PORTLAND MAINE

June 20, 2013

Re: 12 Romasco Lane – 013-I-019 – R-6 Residential Zone – Permit #2013-01241 –
unpermitted deck and egress stairs & landings

4 EAST ELEVATION
A201 SCALE: 1/4"=1'-0"

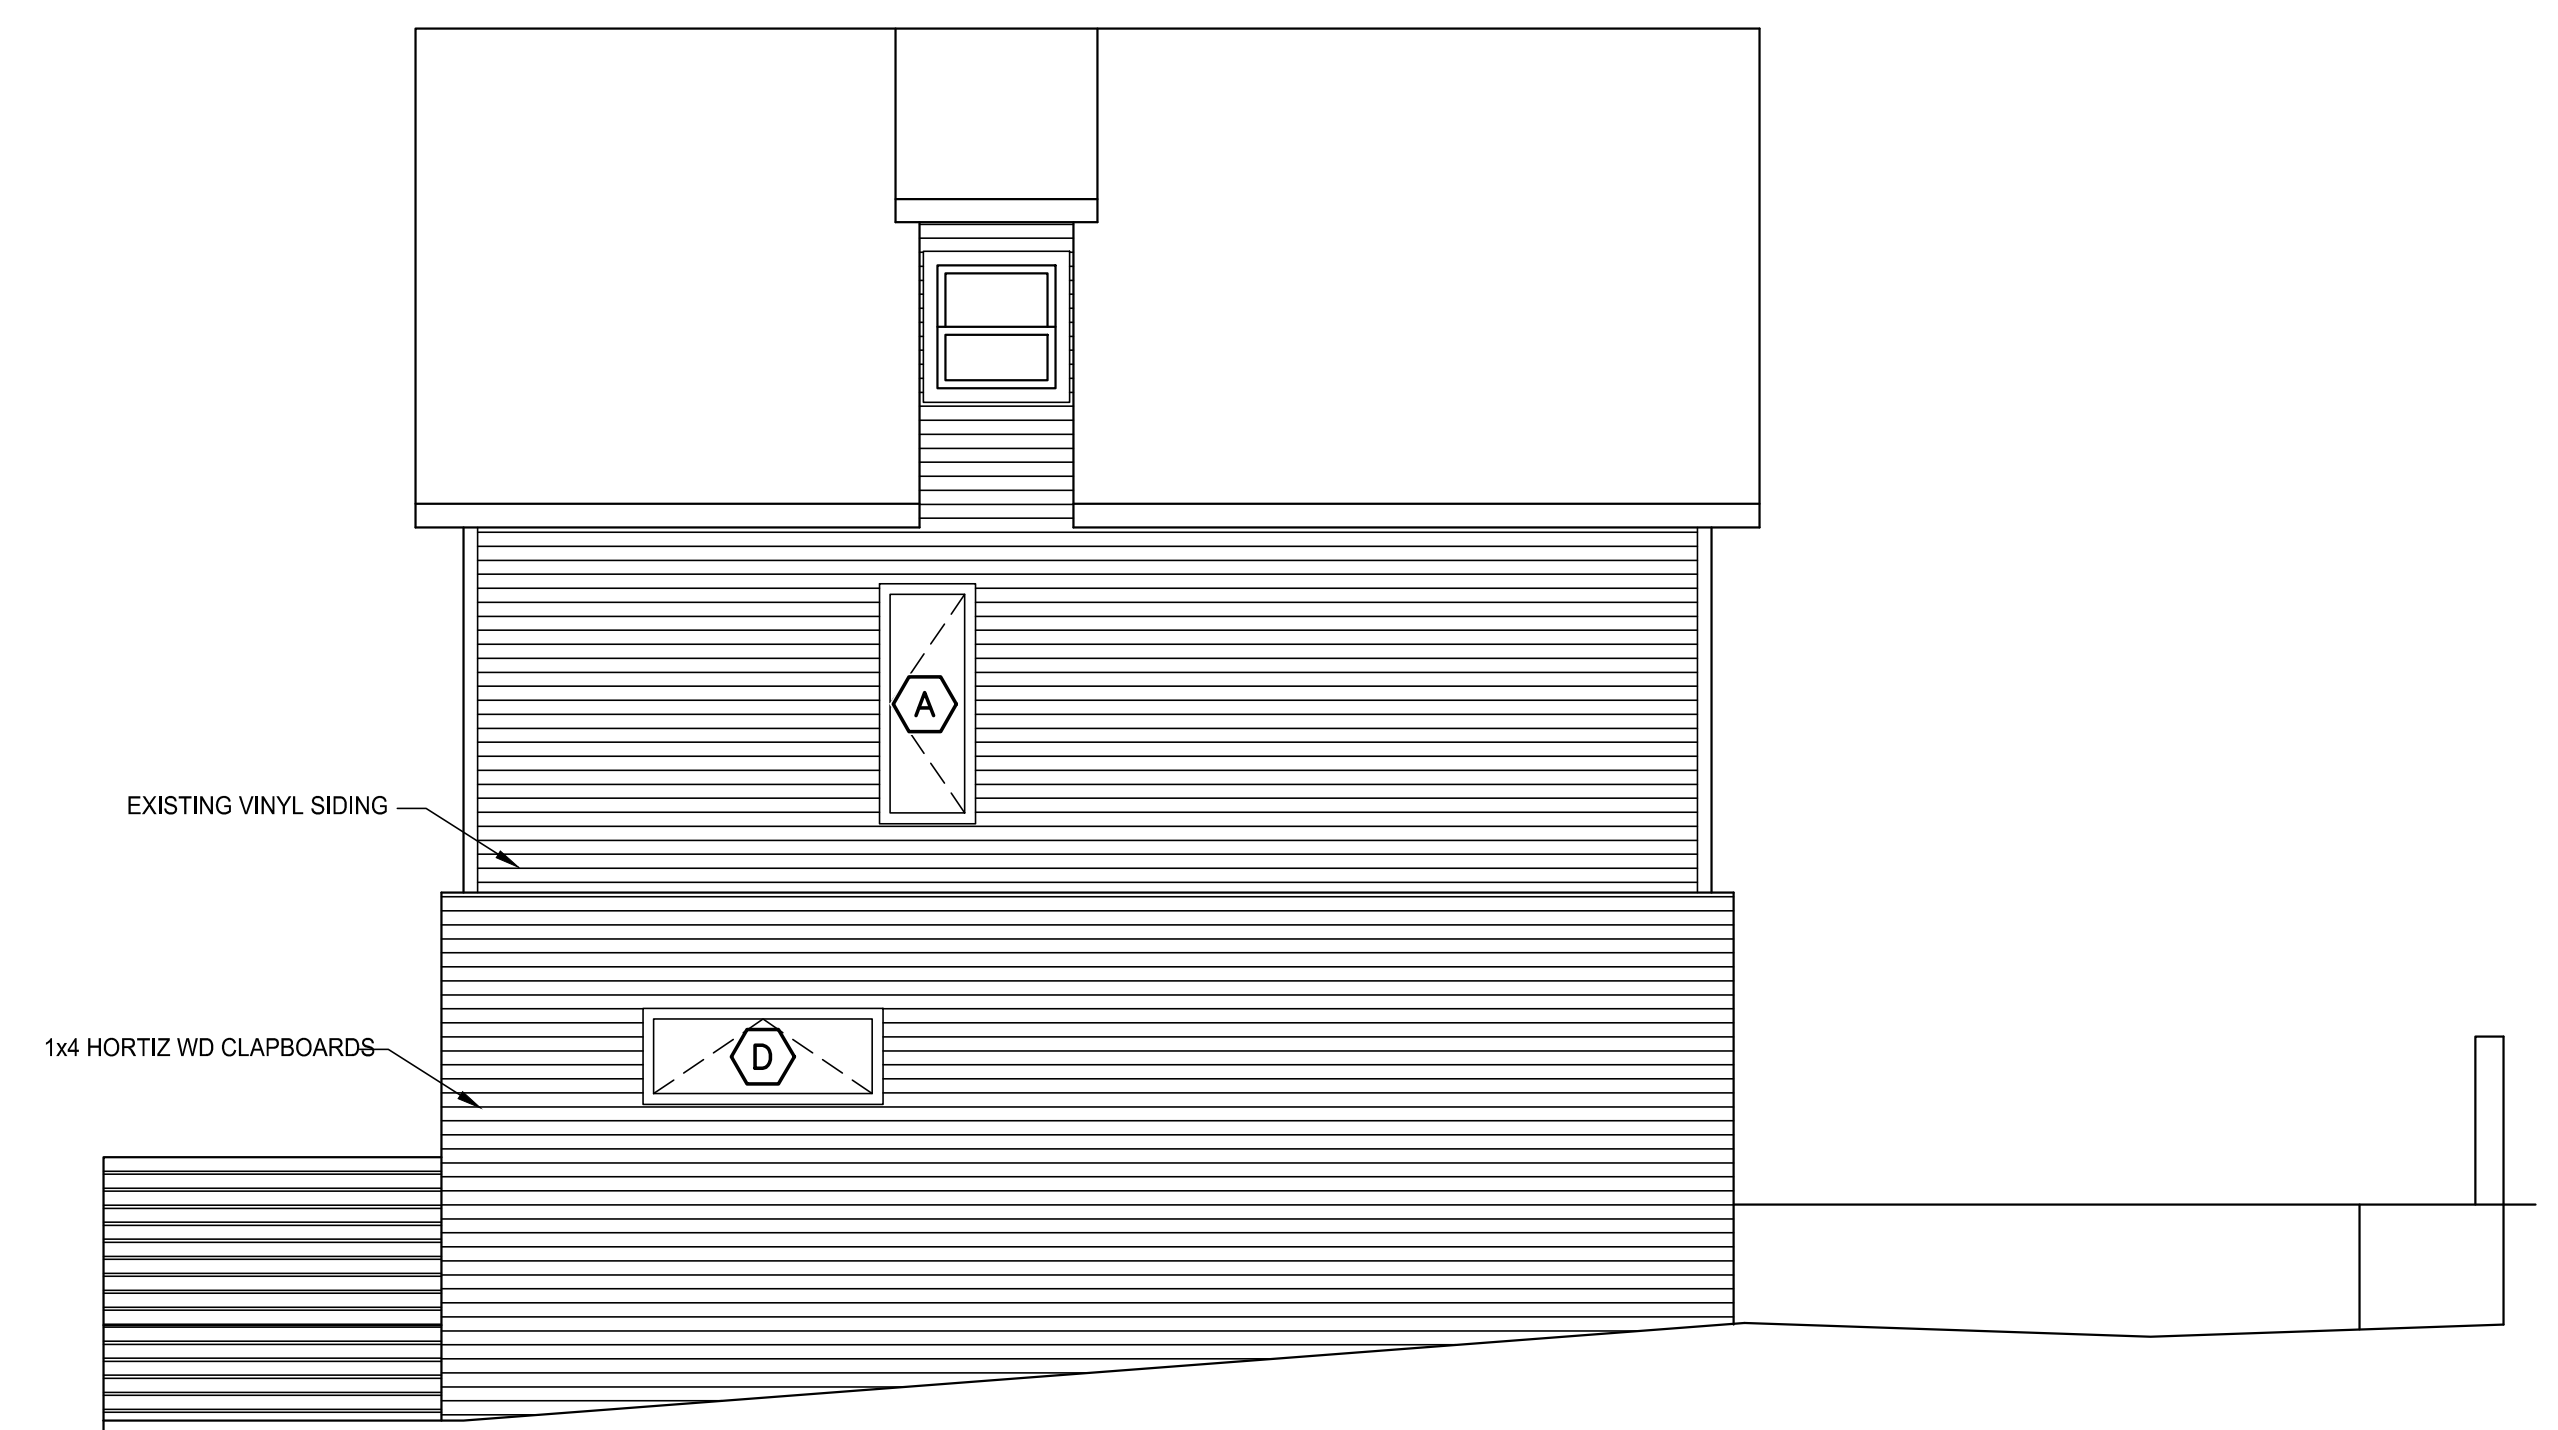
This letter is a follow up to the telephone conversation that we had yesterday. Part of the work that is proposed on the permit is to remove the existing landings and stairs off the rear of the building, and add a second and third floor deck over the existing ground floor deck. The existing and proposed decks go right to the rear property line with no rear setback and the side setback for the existing deck is about 1.4 feet.

12 Romasco Lane is located in the R-6 residential zone. The minimum rear setback [section 14-139(a)(4)(b)] is twenty feet. The minimum required side setback [14-139(a)(4)(c)] is ten feet. The proposed second and third floor decks do not meet either setback. Since the ground floor deck was existing, I researched our files and the assessor's property cards to see if it was permitted. There was no permit for the deck and no footprint of the deck on any of the assessor's cards dating back to the early 1950's. Since the deck was not permitted, it is not legal and since it does not meet the required setbacks it cannot be permitted after the fact. You have thirty days to bring your property into compliance by removing the deck.
